WEST SUSSEX COUNTY COUNCIL CONSULTATION

TO:	Arun District Council FAO: Amber Willard
FROM:	WSCC - Highways Authority
DATE:	17 February 2021
LOCATION:	14 East Bank North End Road Yapton BN18 0DJ
SUBJECT:	Y/7/21/HH Would like to apply to have a dropped kerb
DATE OF SITE VISIT:	n/a
RECOMMENDATION:	Advice
S106 CONTRIBUTION TOTAL:	n/a

The proposal is for the construction of a Vehicle Crossover (VCO).

Proposed Plan - 1:100 @A1

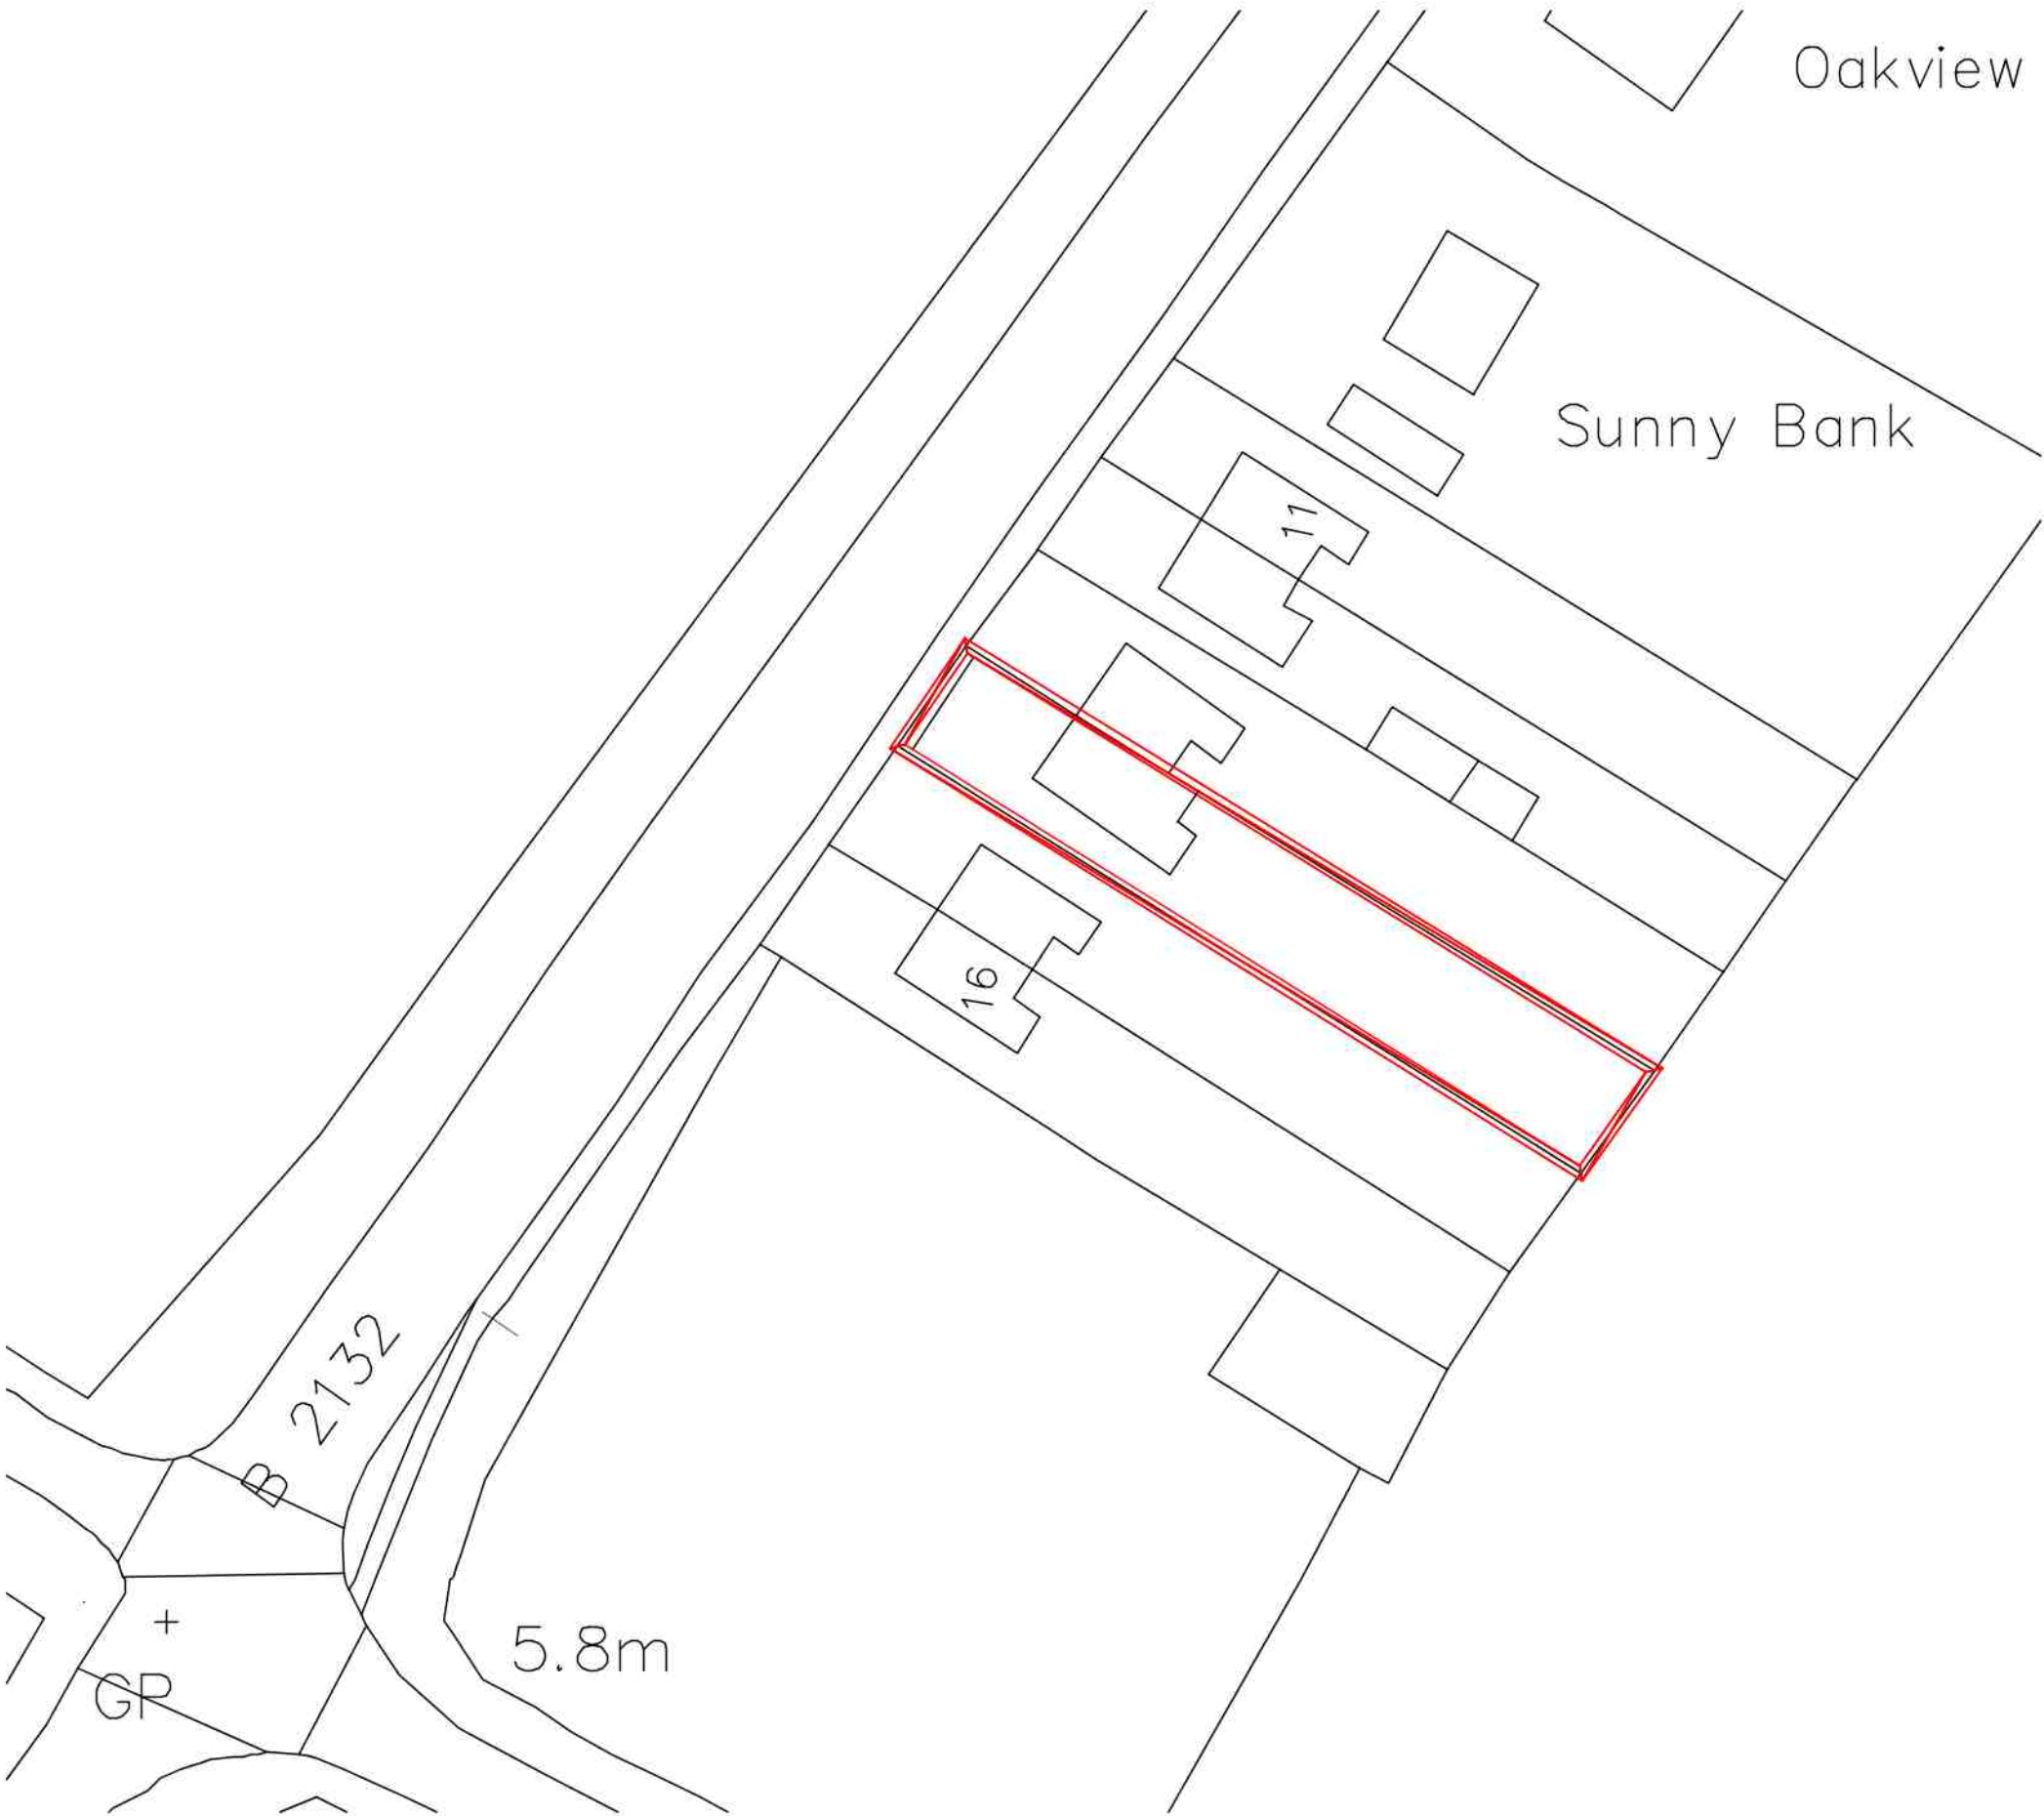
The LHA wish to state that VCO's normally are wider at the kerbside and taper back towards the driveway to assist in ease of access. Details for this however can be secured via a suitably worded condition.

The use of the car parking space(s) shall not commence until the vehicular access has been constructed in accordance with plans and details **to be** submitted to and approved in writing by the Local Planning Authority.

Visibility Splays - 1:500 @A1

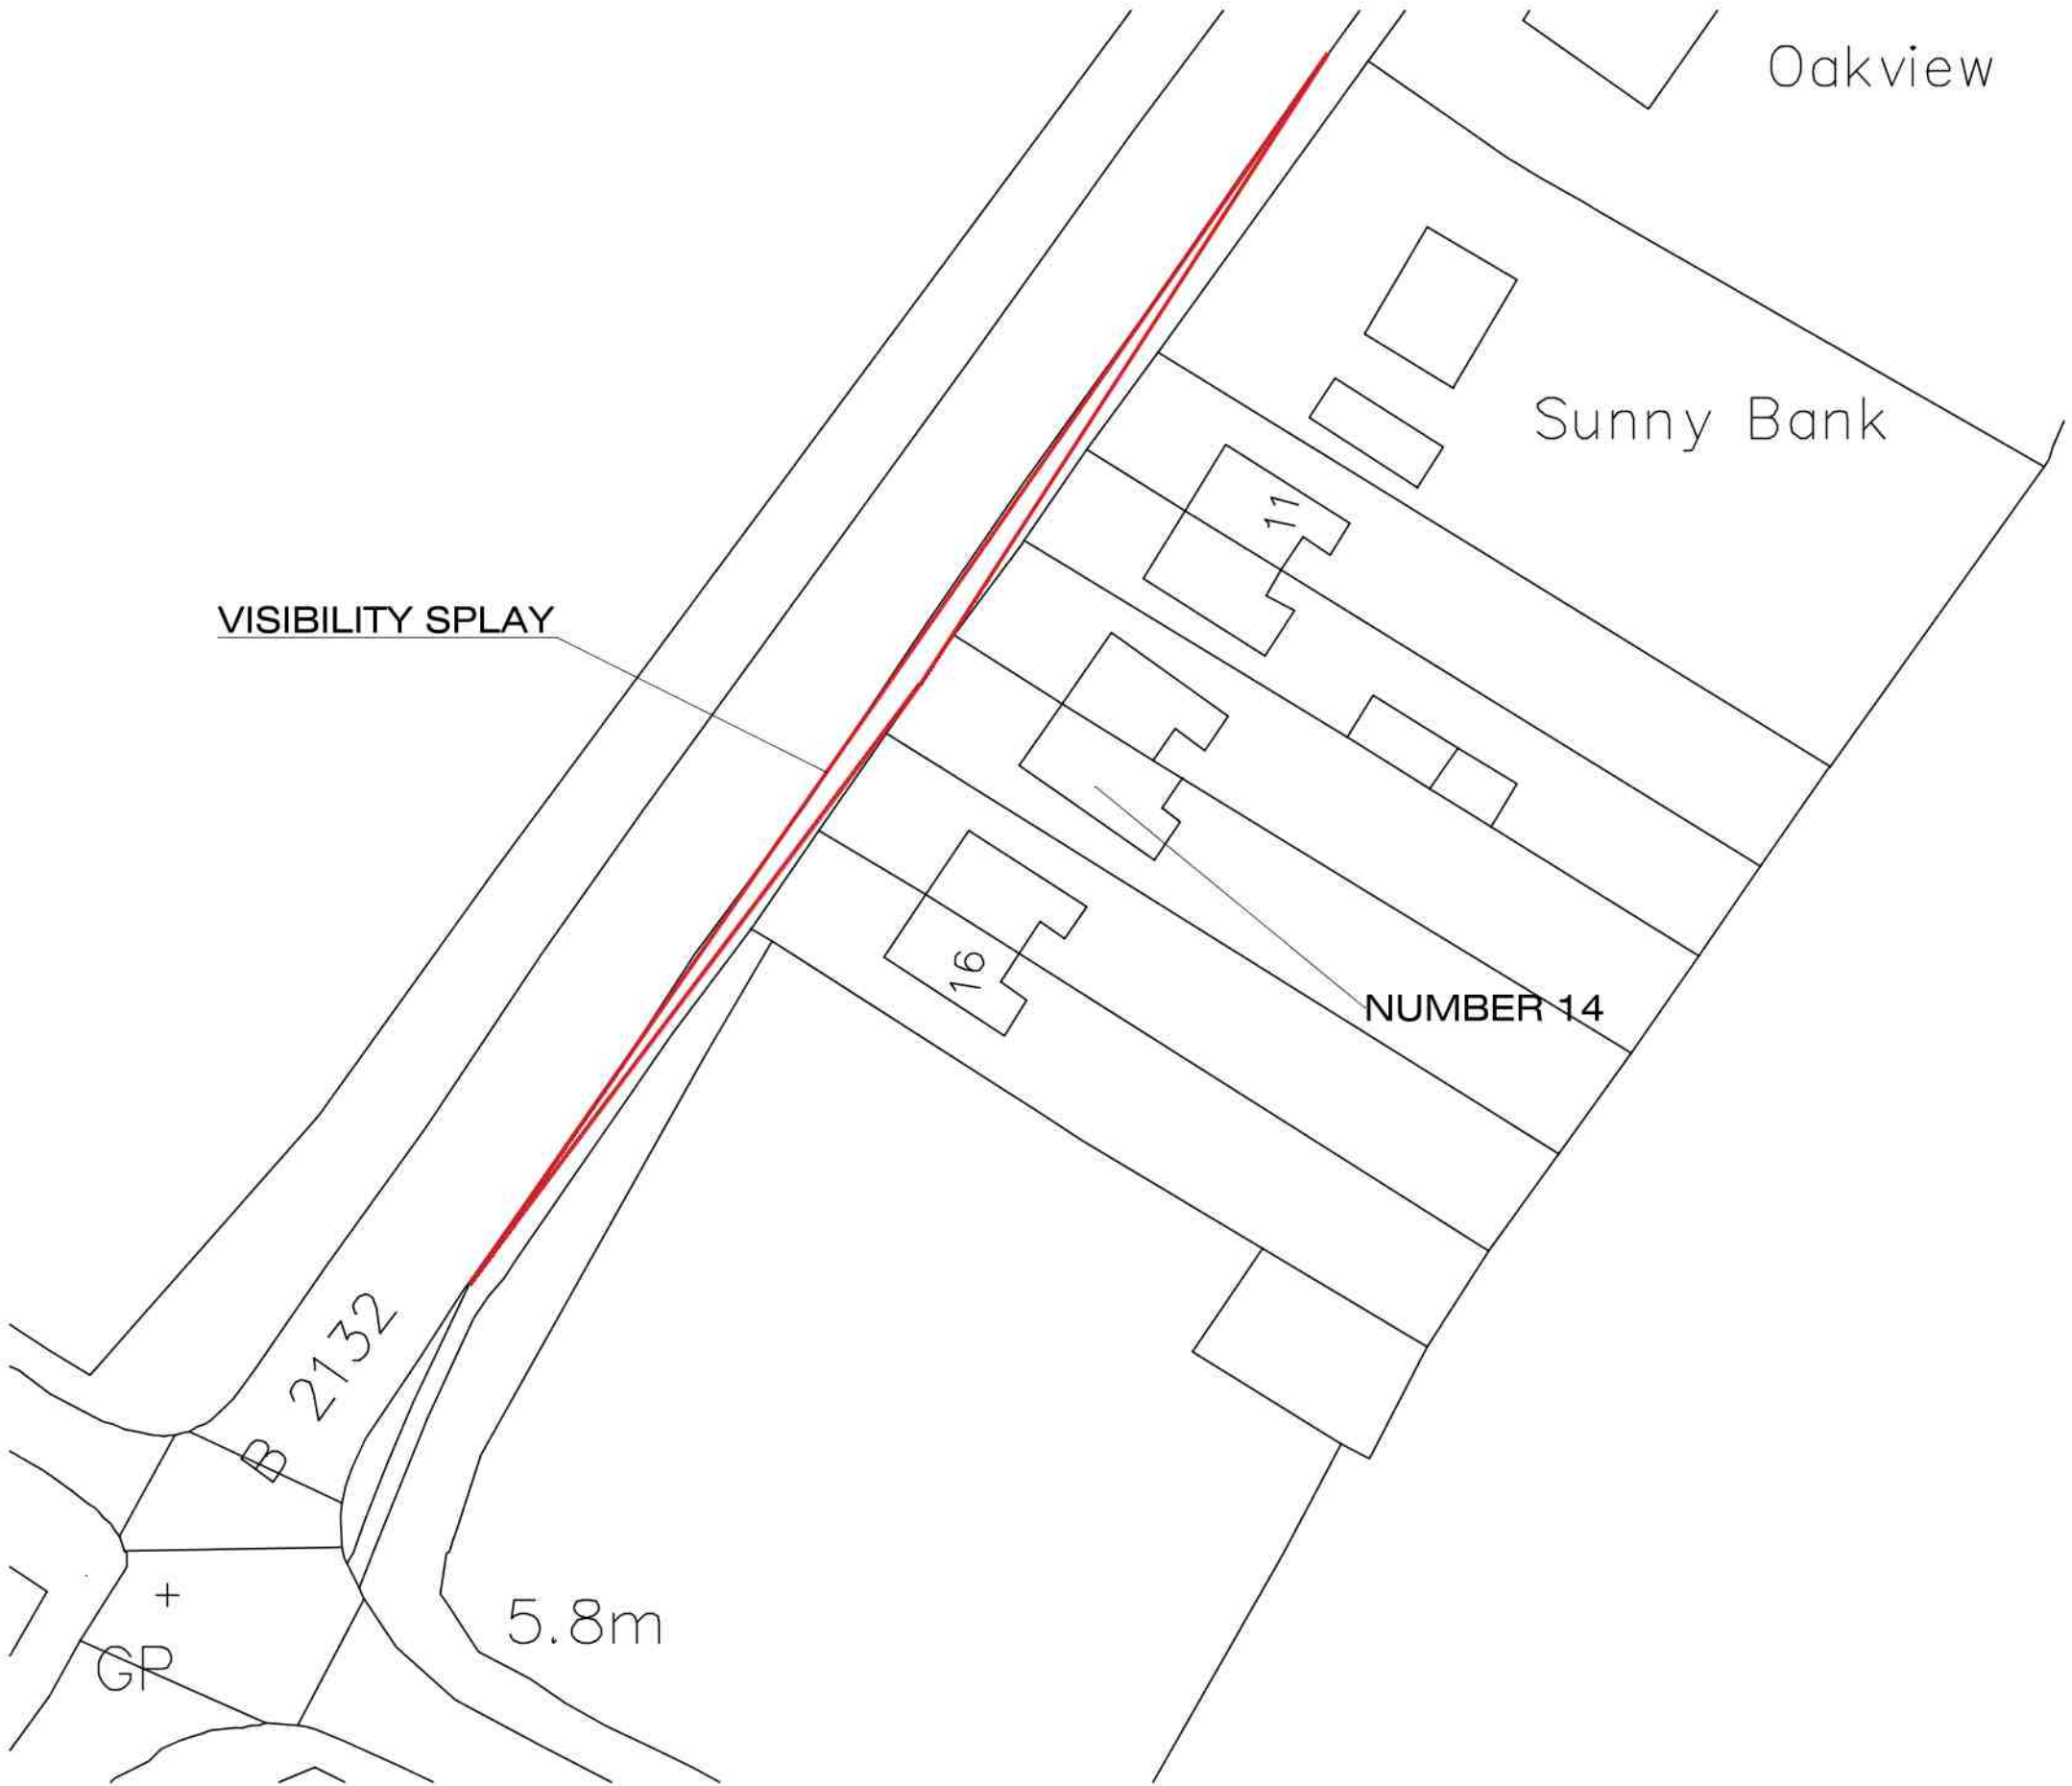
The applicant has provided vehicle visibility for the proposed. However, these details have been demonstrated incorrectly. This said, MfS guidance states that, Vehicle exits at the back edge of the footway mean that emerging drivers will have to take account of people on the footway. The absence of wide visibility splays at minor accesses will encourage drivers to appear more cautiously - similarly, to how vehicles pull out when

visibility along the carriageway is restricted. Following this guidance, the LHA raises no concerns over the lack of the details.
